8 May 2008

Letter DoP - Modification - Demolition Ver 2.doc
EN01893

AMCOR Paper Mill, Matraville (05_0120) – Modification of Project Approval to Include Demolition of Additional Infrastructure.

Figure 2: Proposed Demolition at the Facility

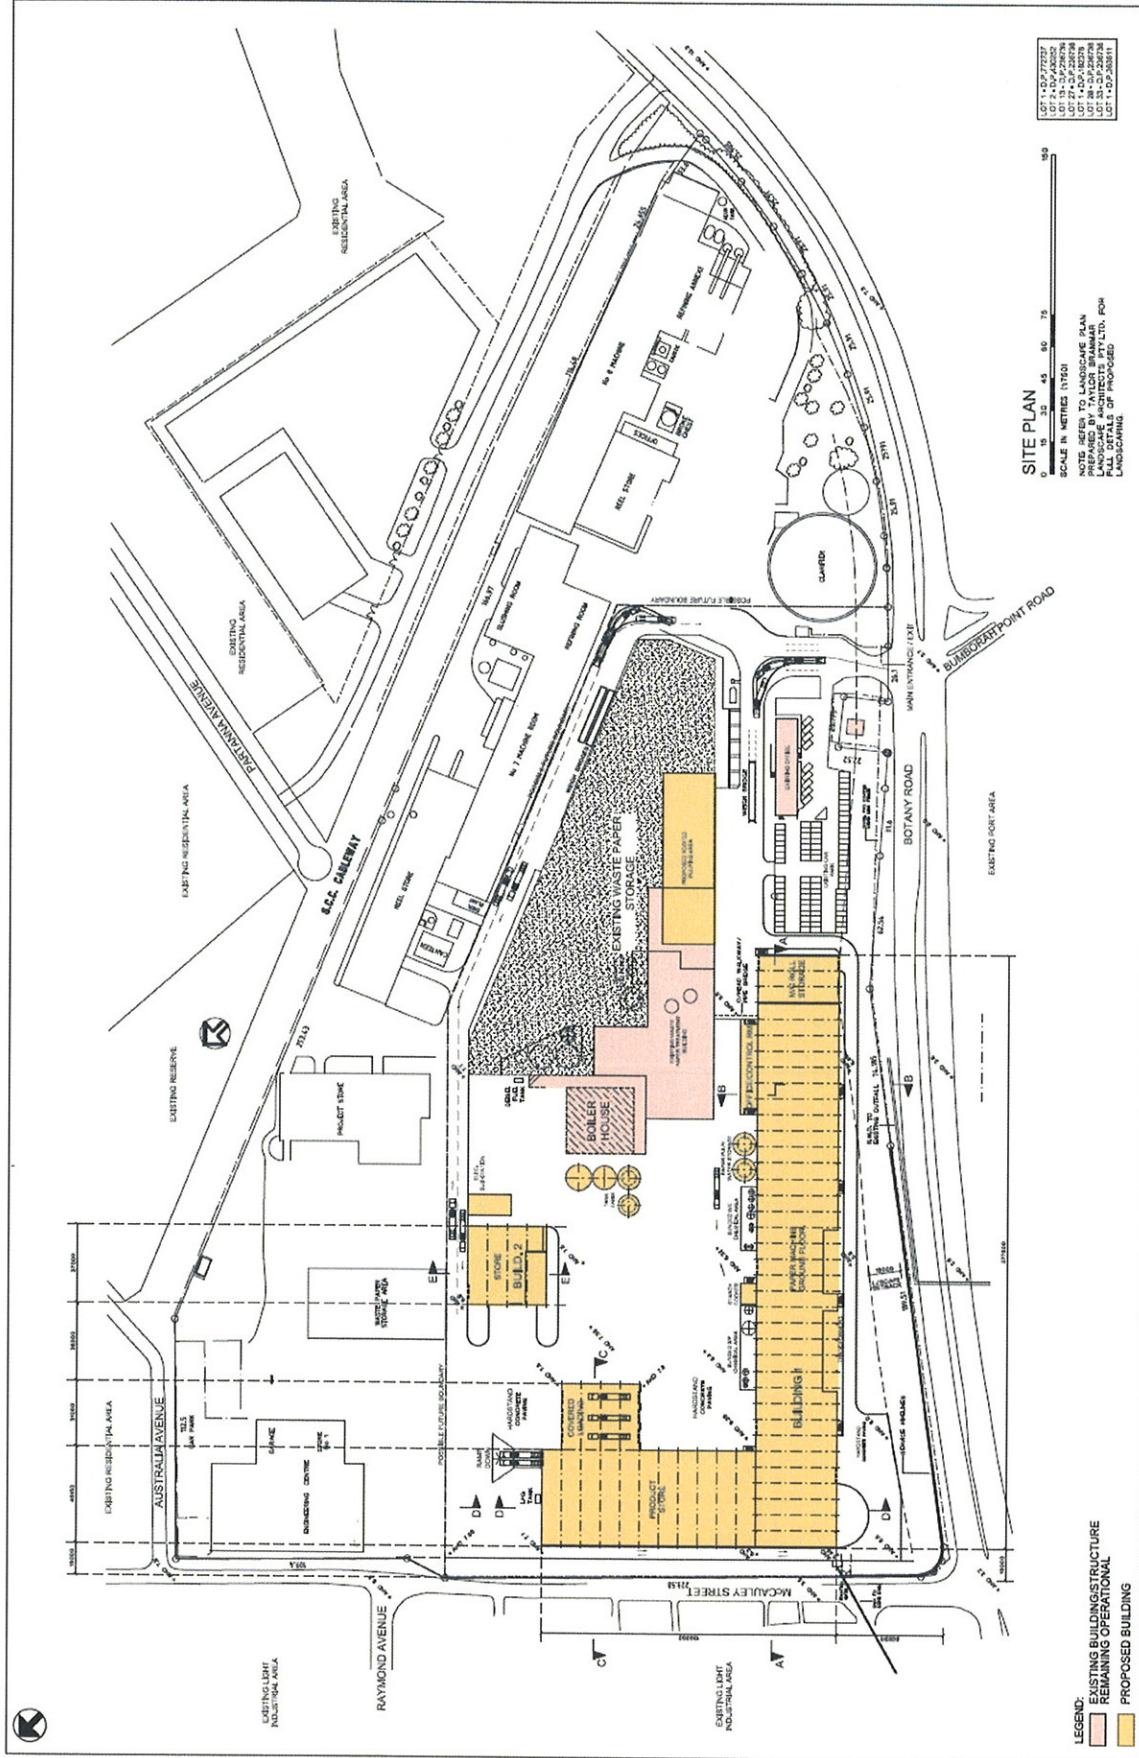
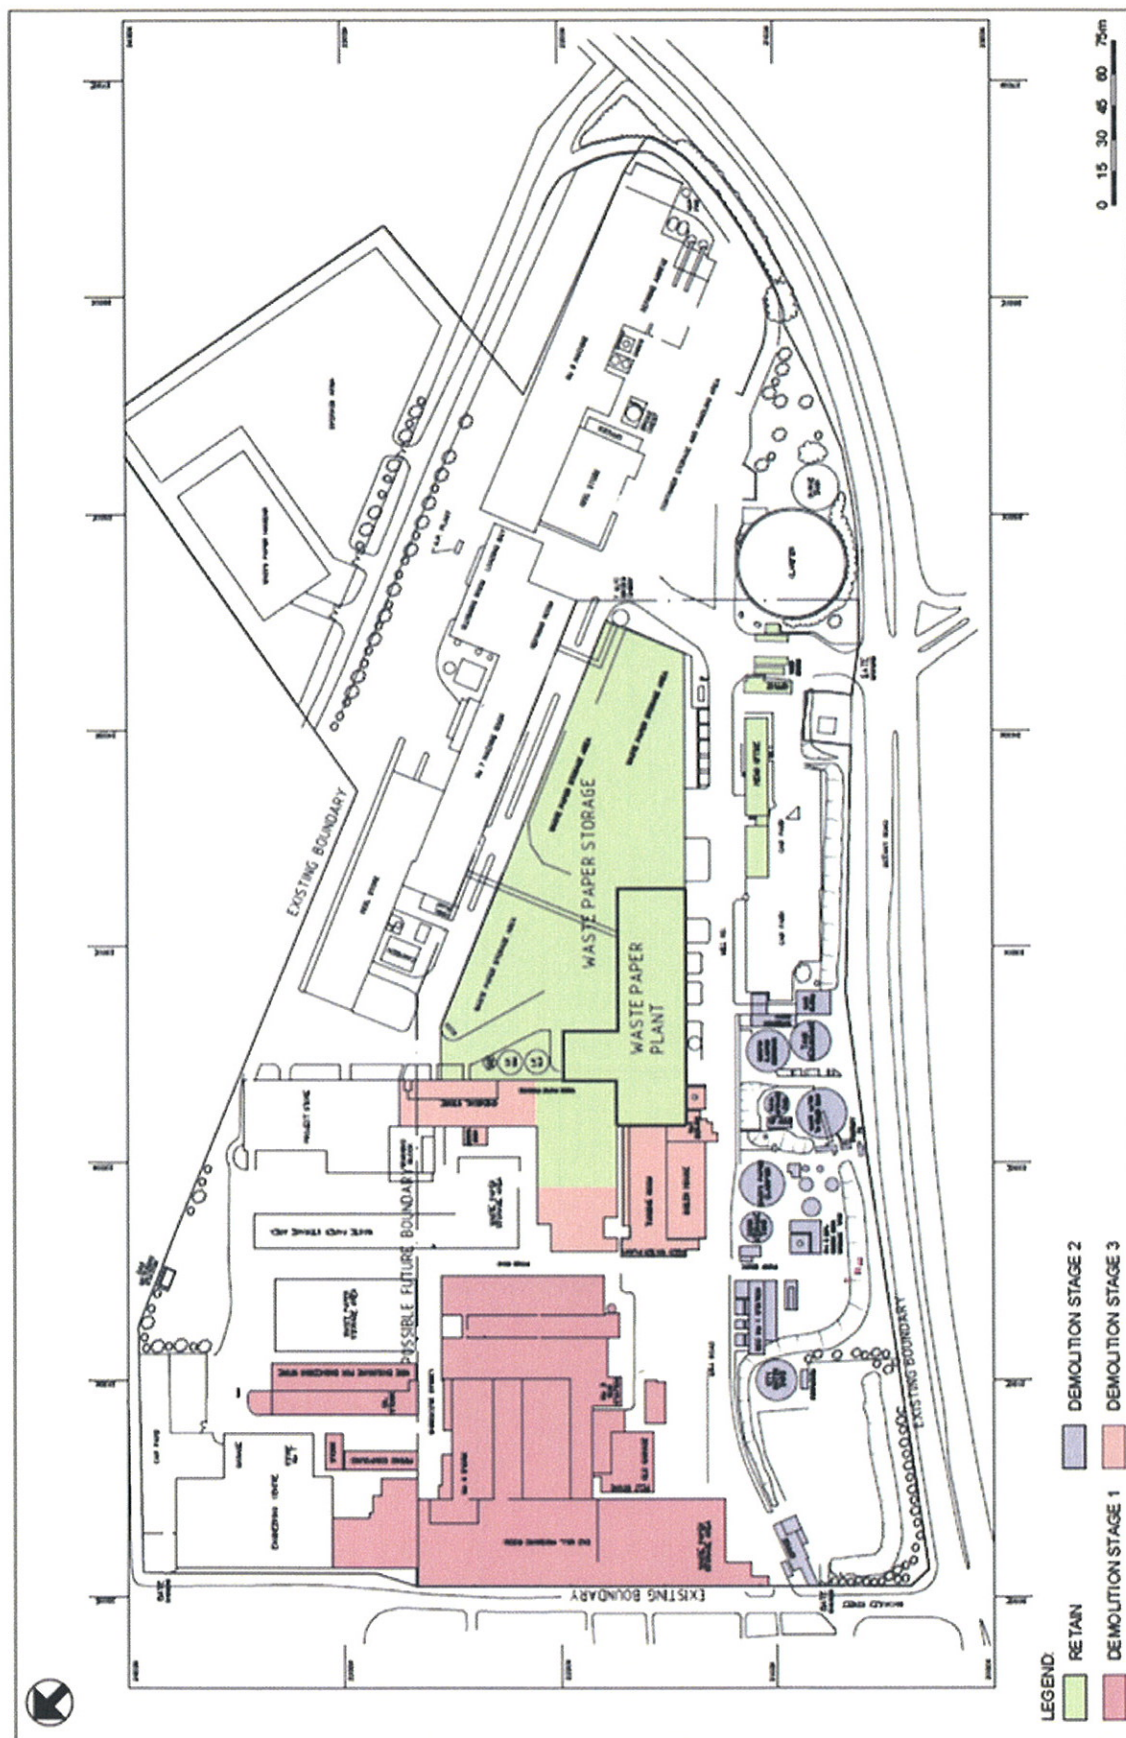
- 1) Within the New Paper Mill boundary the Demolition Figure (5-3) only identified buildings and major infrastructure that would require demolition. Other infrastructure (for example roads, kerbing, pipe bridges and stormwater pipes) would also require demolition in this area.

- 2) Within the New Paper Mill boundary, demolition of a section of the existing Waste Paper Plant building is required to allow the installation of large pulp and process water storage tanks required for the waste paper recycling process.

- 4) North of the Possible Future Boundary, the Engineering Centre (including Store No:1 and Garage) was originally not identified as requiring demolition. With the demolition of the McCauley St heritage wall and the removal of asbestos roofing this building would not be safe and now requires demolition.

- 5) North of the Possible Future Boundary, the Project Store (including Training Block) was originally not identified as requiring demolition. With the removal of asbestos roofing this building would not be safe and now requires demolition.
- 6) North of the Possible Future Boundary, the pavement and building foundations are intended to be largely kept, however in some areas they may be demolished to allow the installation of services such as stormwater, water and gas.
- 7) The office buildings, associated car park, site entrance and weighbridge may require demolition depending upon the final design of the New Paper Mill. Rather than apply for a separate modification if demolition of these structures are required, it was considered appropriate to include the possibility of demolitions in this application.

The Demolition Figure (Figure 5-3) has been updated and is attached to this letter. Rather than specifying stages of demolition as per the original figure, this information has been removed and information on staging of demolition will be presented in the construction environmental management plans.
